Drainage _V5.pdf Markup Summary

PROPOSED
DRAINAGE MAP

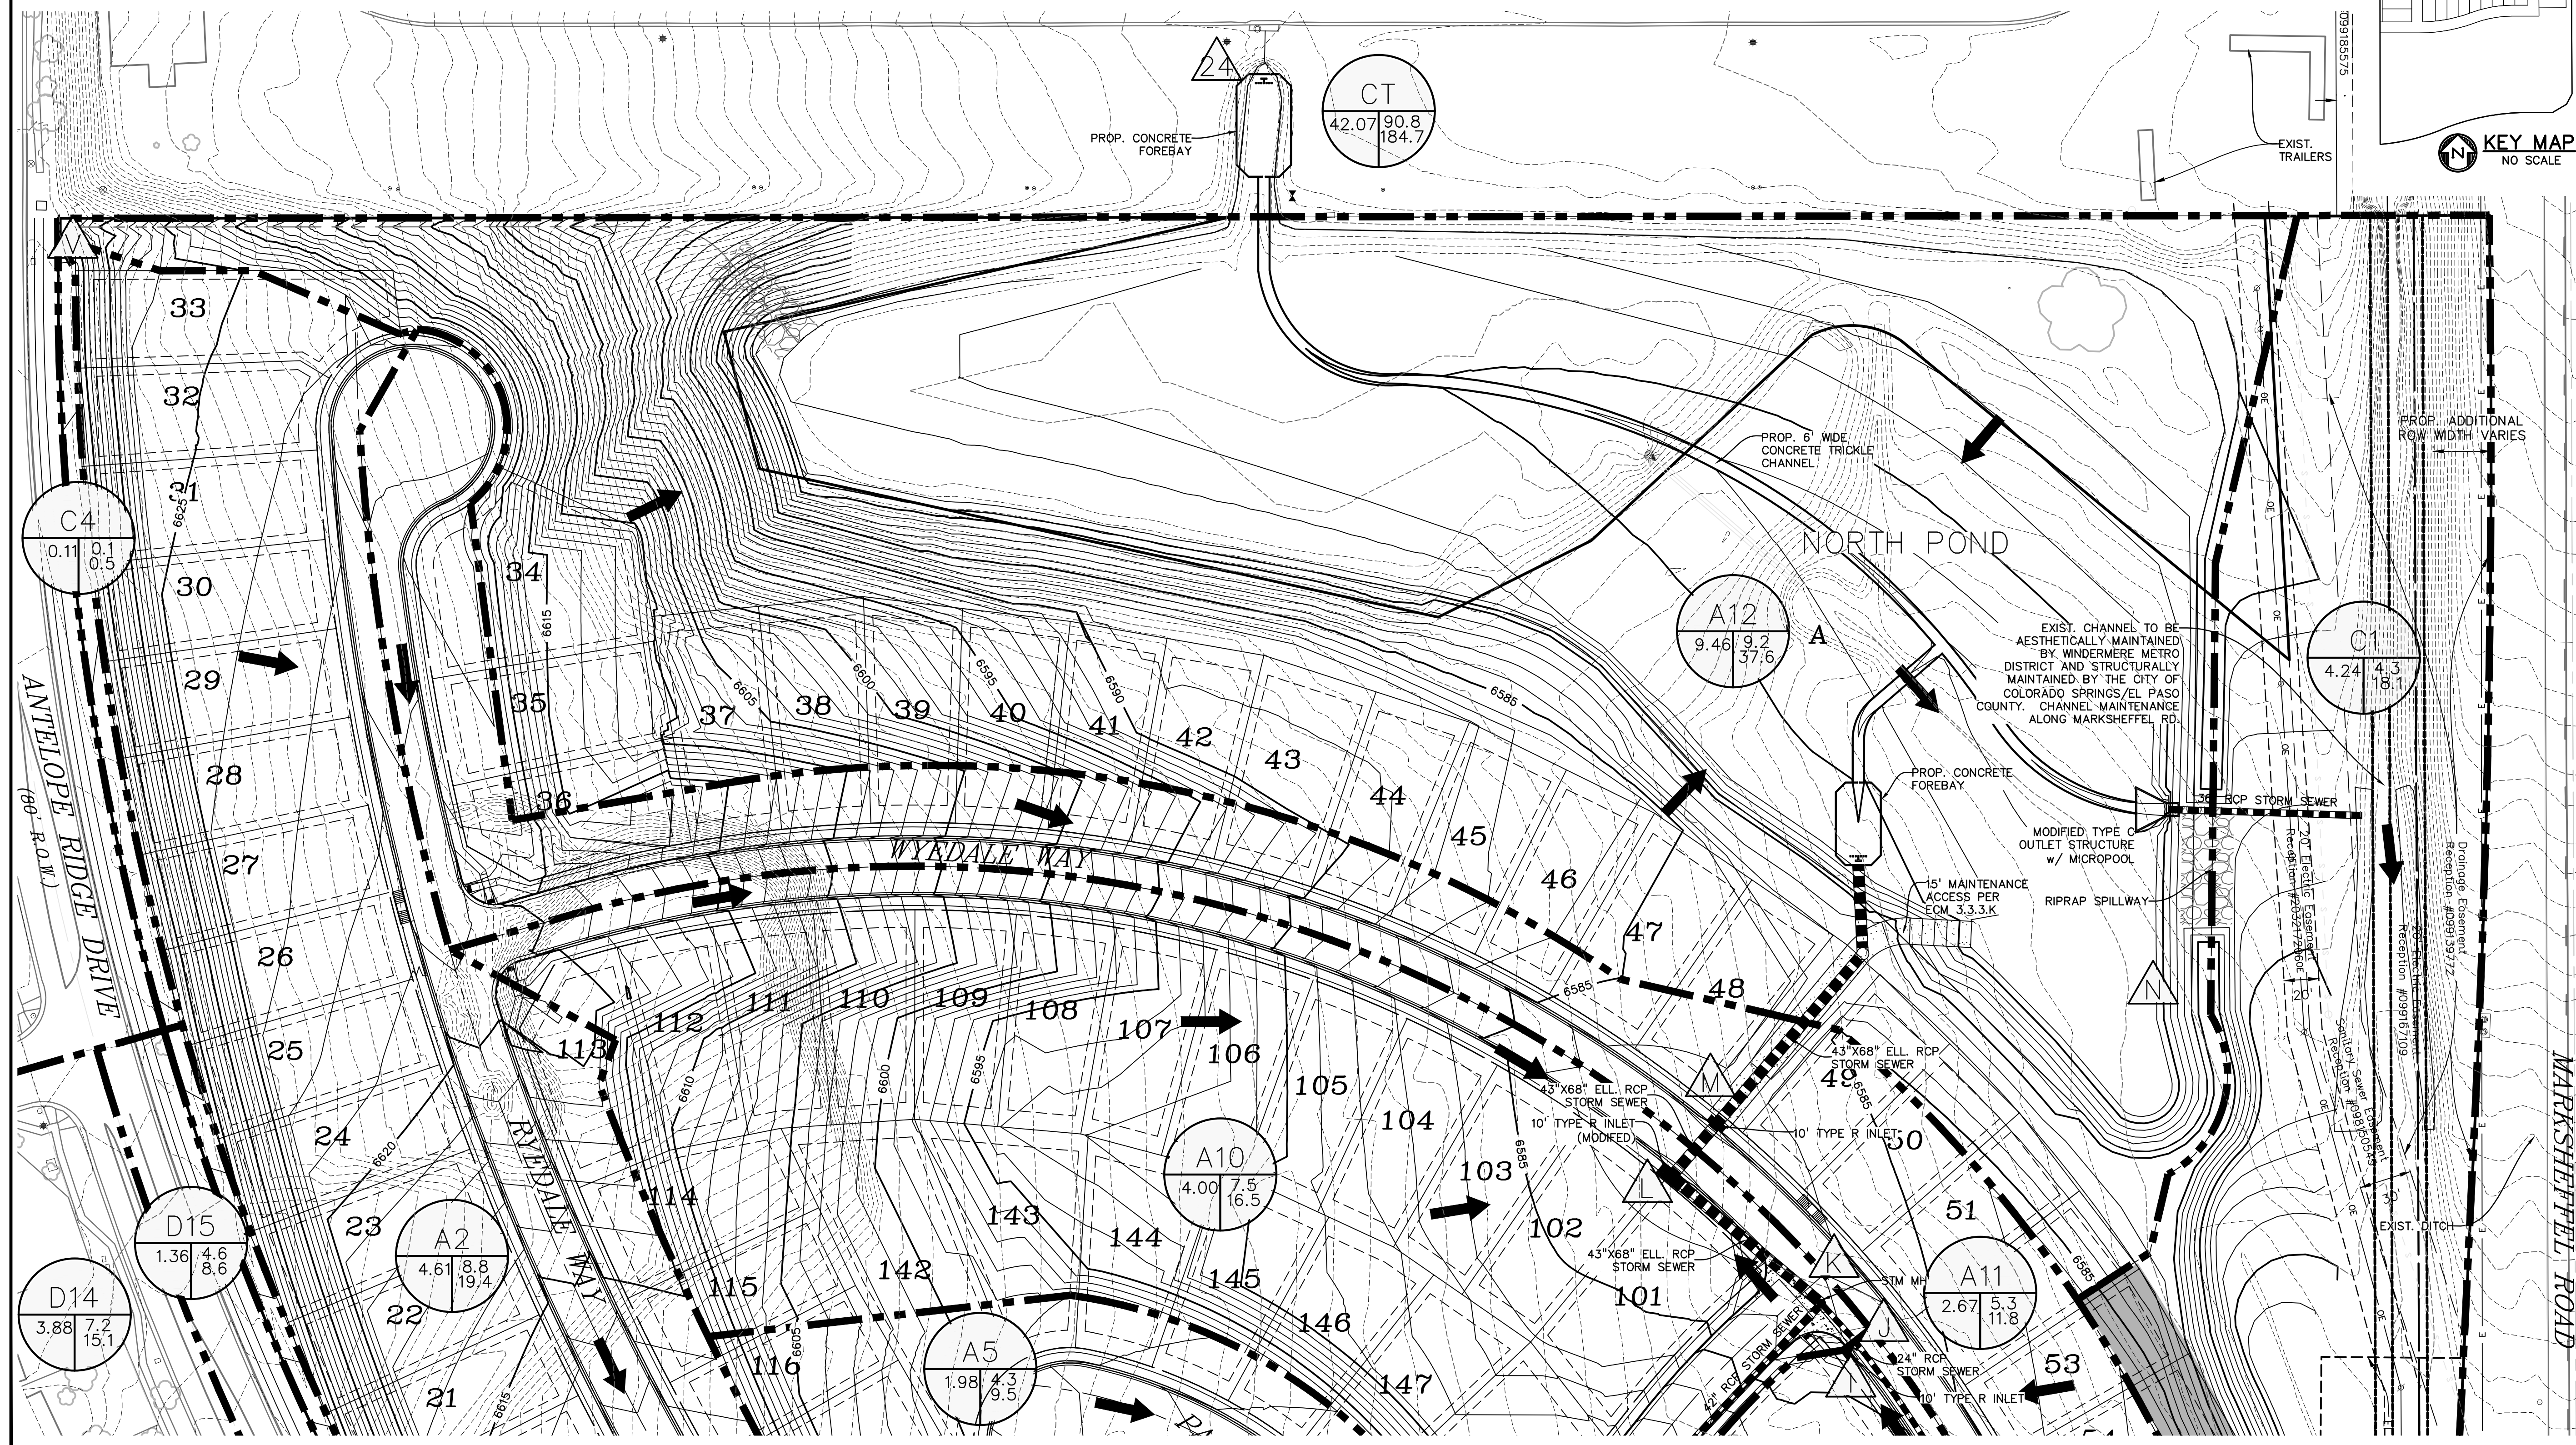
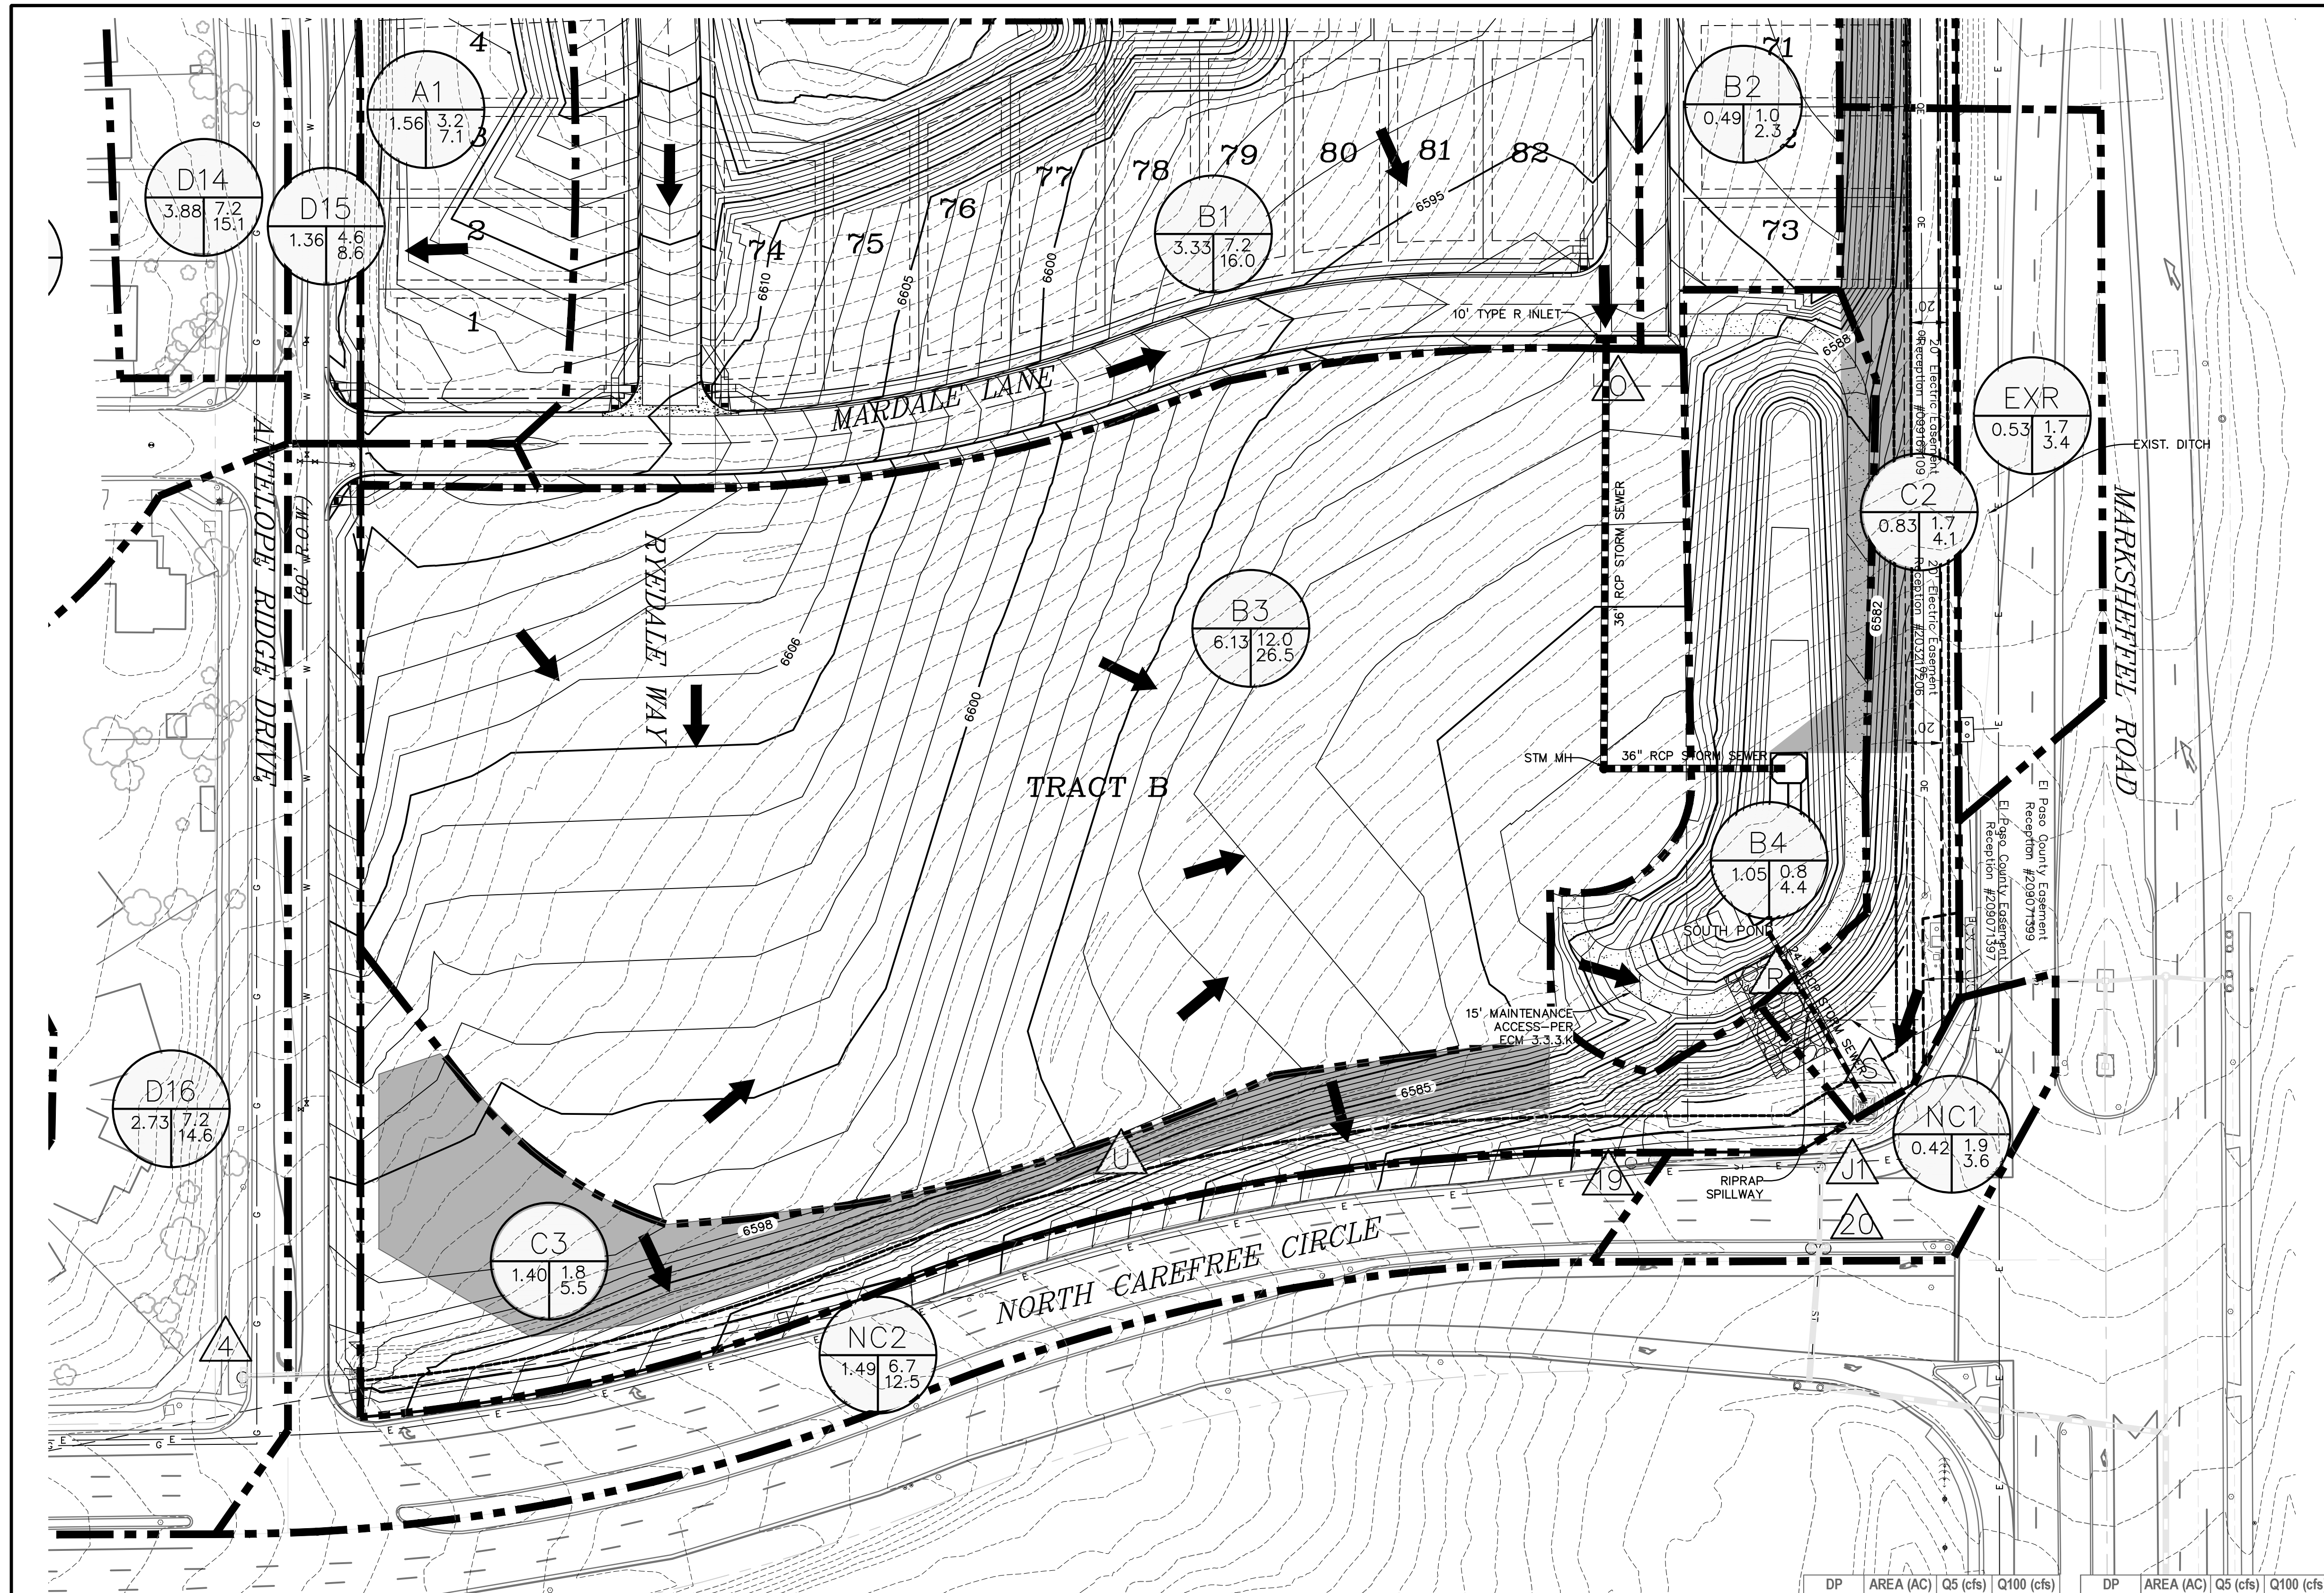
The receiving ditch along the west side of Marksheffel has not been analyzed as part of this report.
